NON-MATERIAL AMENDMENT FOR MINOR RELOCATION OF PLANT ENCLOSURE AT BUILDING 141, THE COMMAND WORKS, BICESTER HERITAGE, SOUTHERN, BICESTER, OX27 8FA.

On behalf of our client, Motorsport UK, Edgars hereby submits a Non-Material Amendment for minor changes in relation to the approved location of plant enclosure as shown on approved site plan and elevations secured under application reference: 20/00832/F at Building 141, Bicester Heritage, Buckingham Road.

This application seeks to amend minor elements of the approved planning permission allowed by ref 20/00832/F which secured "*Variation of condition 1 (plans) of 20/00842/f to allow for external alterations to Building 141*" on 18th June 2020.

TITLE:
SW Proposed GA Sections

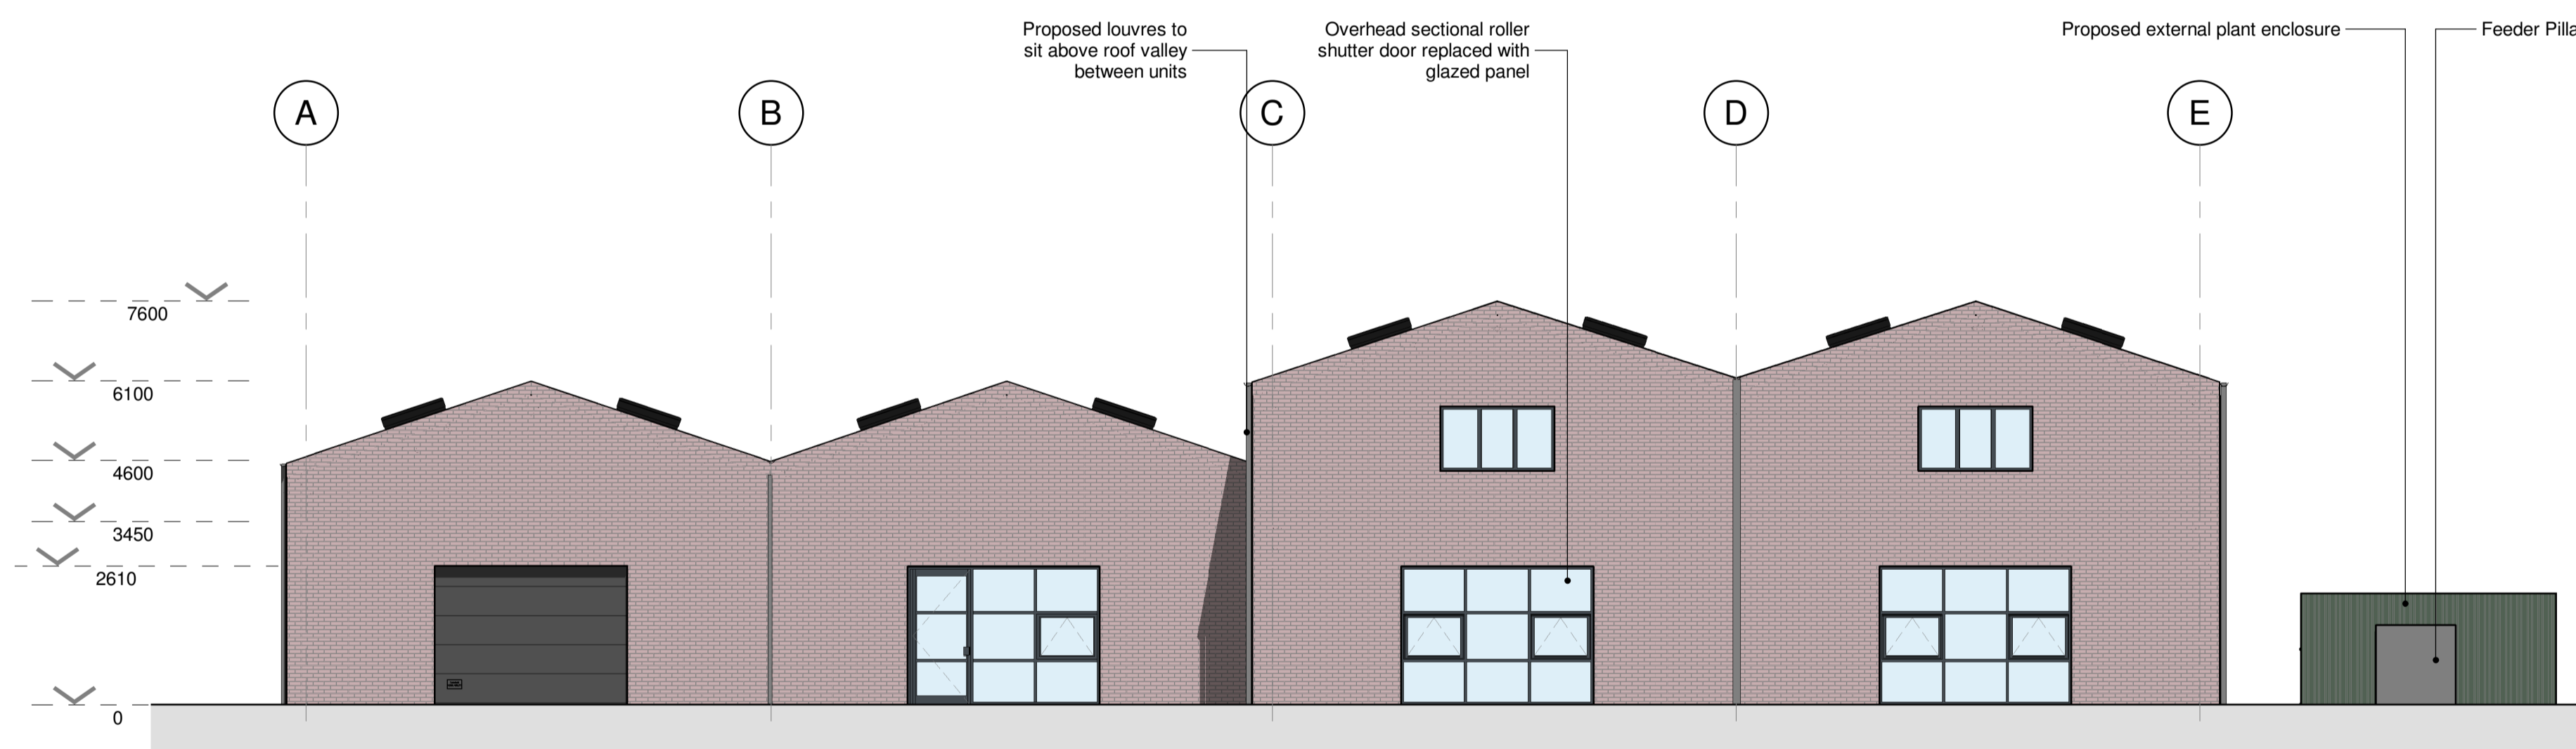
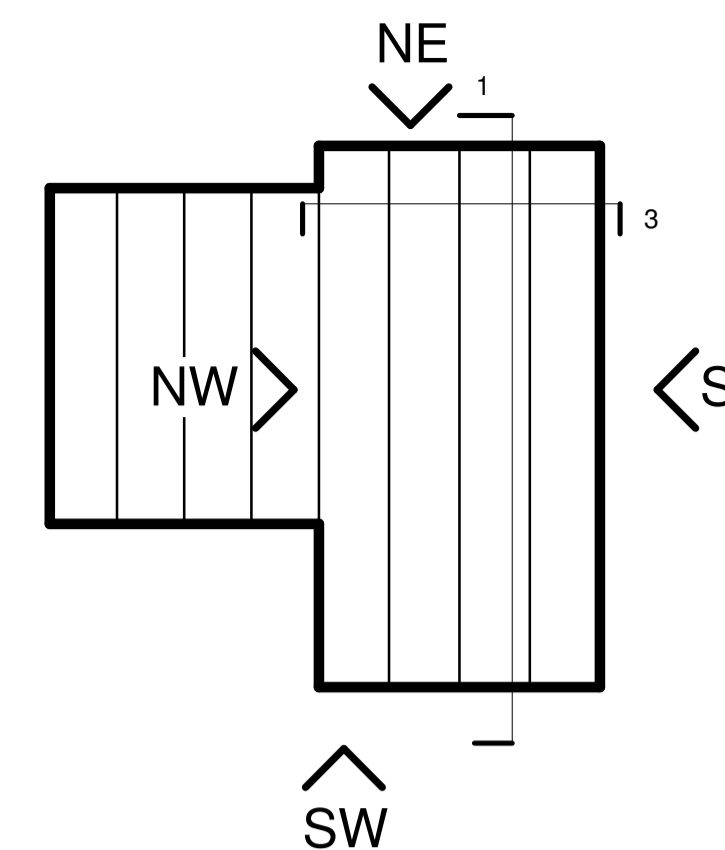
The proposed plans show the external plant relocated approx. 5.5m south west from the approved location. The siting is still located adjacent the south-east elevation of Building 141, while the total footprint has been reduced by nearly 50% following further consideration in regard to the equipment housed in the plant area. The reduction in size reduces any visual impact of the plan enclosure and releases external area.

**EXTERNAL CONDENSER COMPOUND
& CAR CHARGING POINTS**

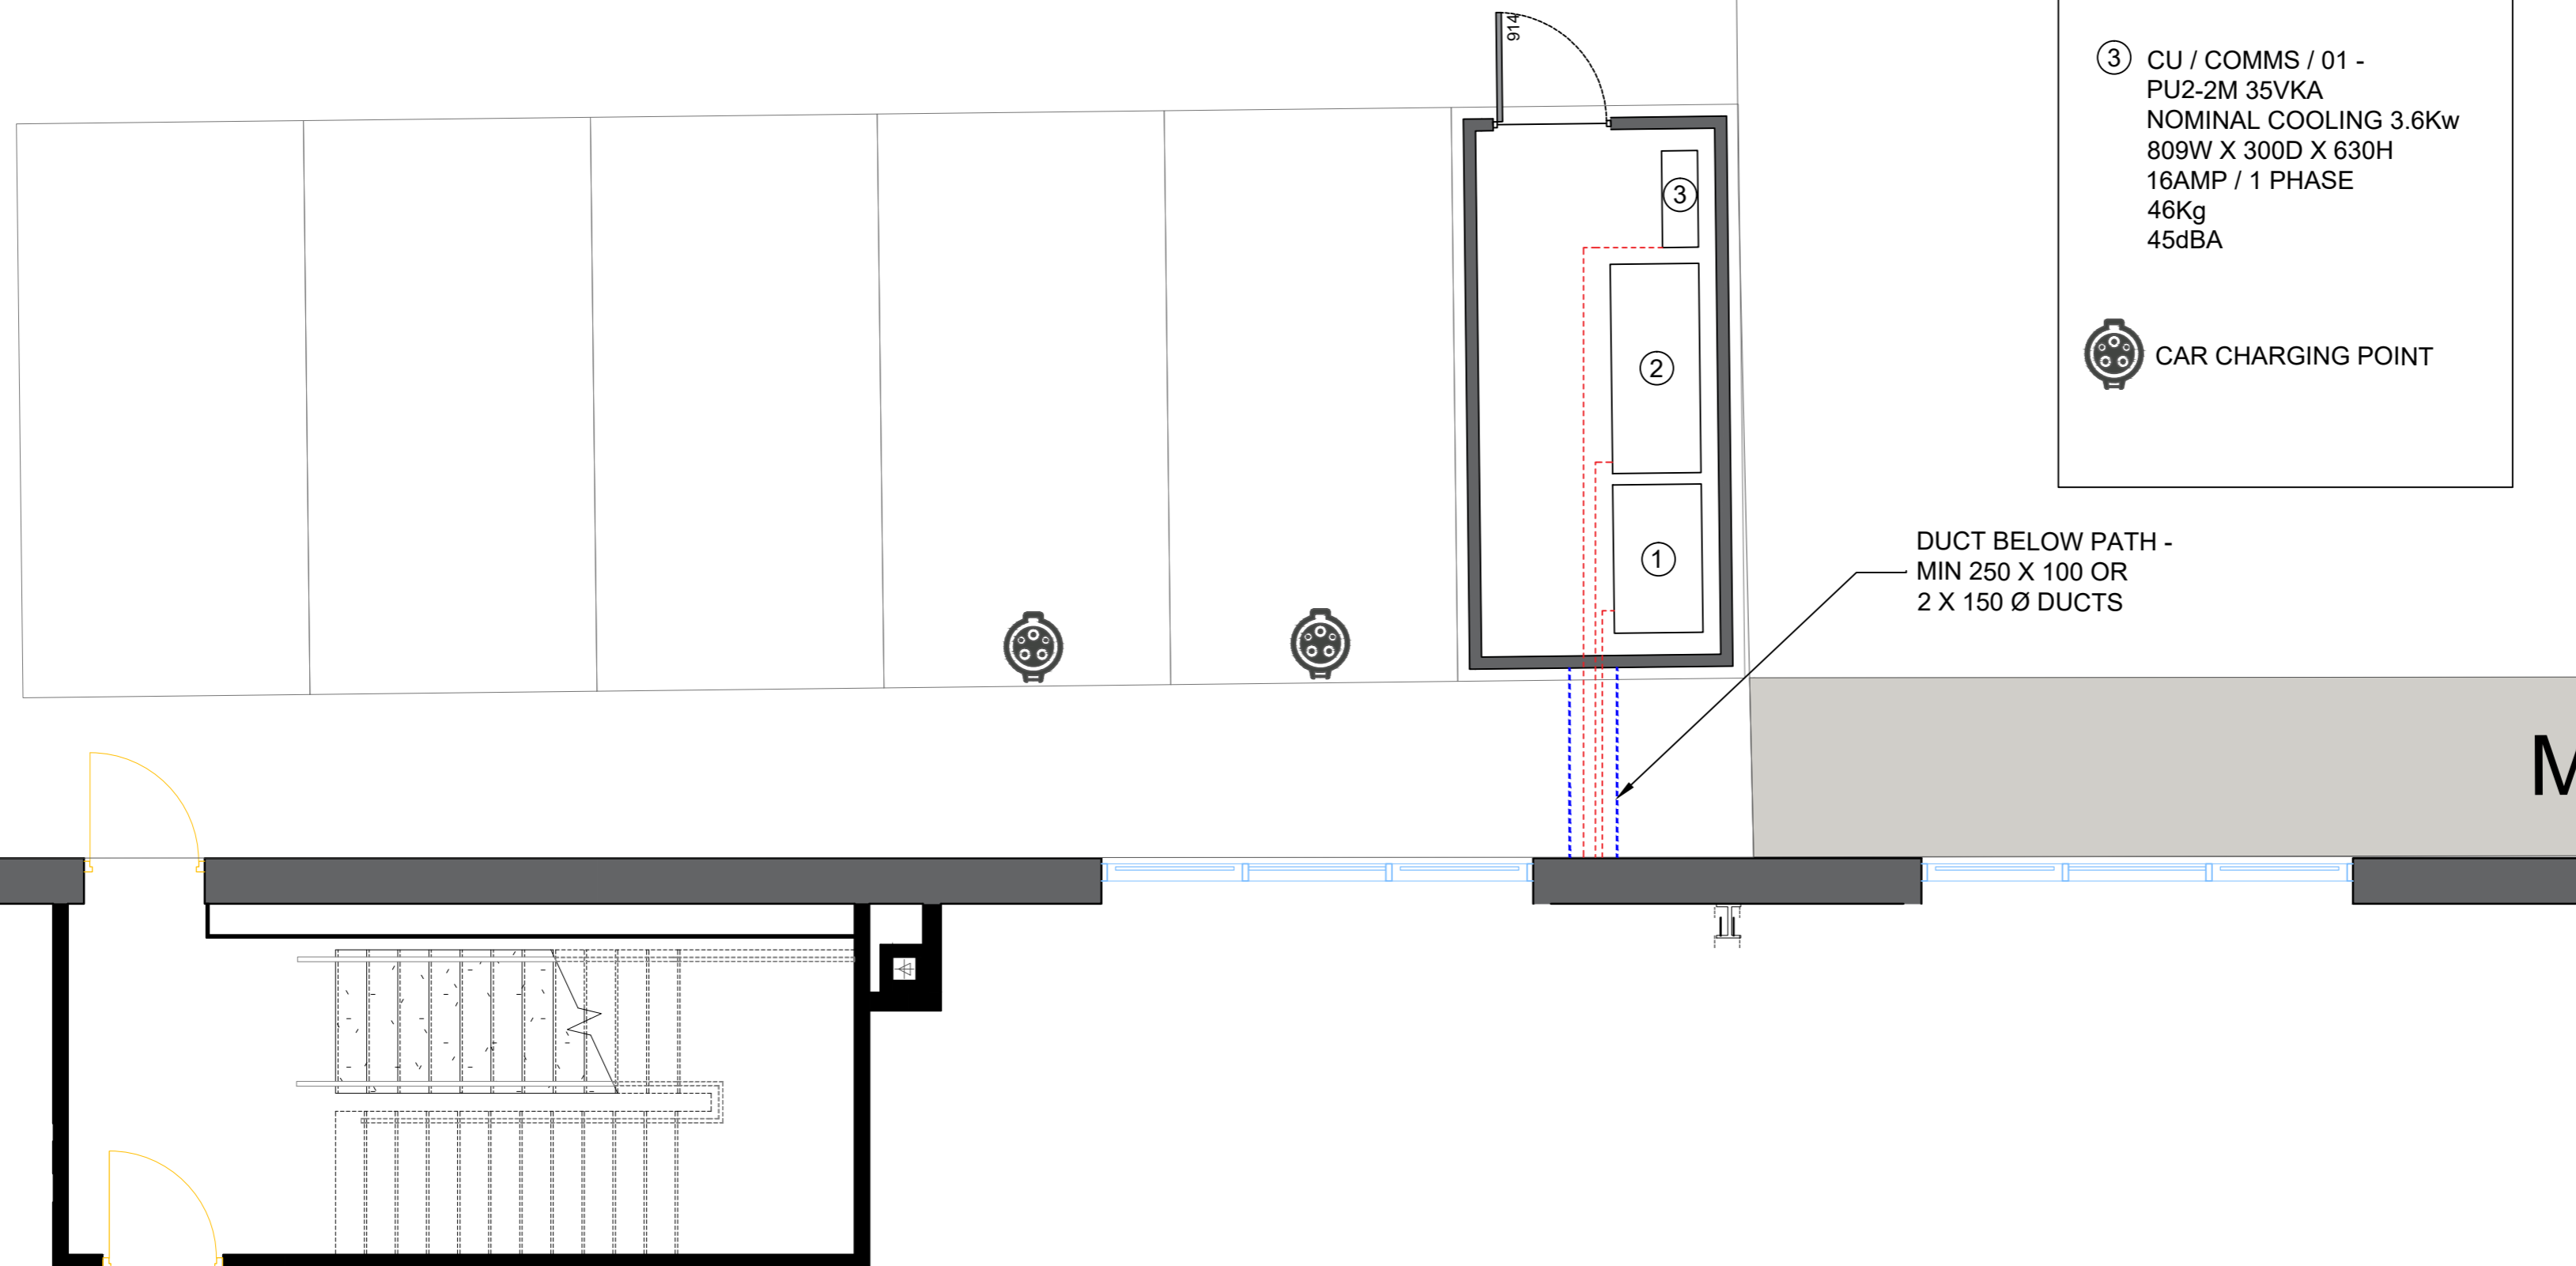
Specifically, this non-material amendment seeks to minorly amend the location of the enclosed plant room adjacent Building 141. Its approved and proposed location can be seen in figure 1 below.

Following the grant of planning consent 20/00832/F the applicant sought to implement the approved works. Upon a review of the site, it was noted that the siting of the approved plant area required the repositioning/removal of a pre-existing power pillar not captured by the approved plans. Consequently, the applicant has sought to relocate the enclosed plant area via a non-material amendment.

TITLE:
SE Proposed GA Elevations

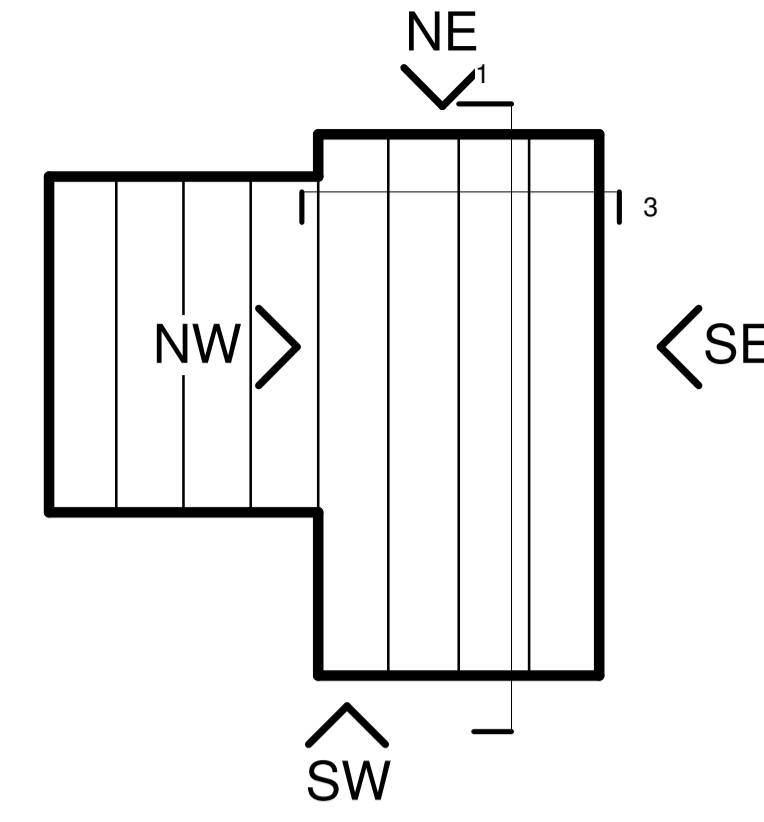
The proposed location has been selected not to obscure the approved window locations of Building 141 and is situated in a gap between them. The proposed materials have not changed from those approved.
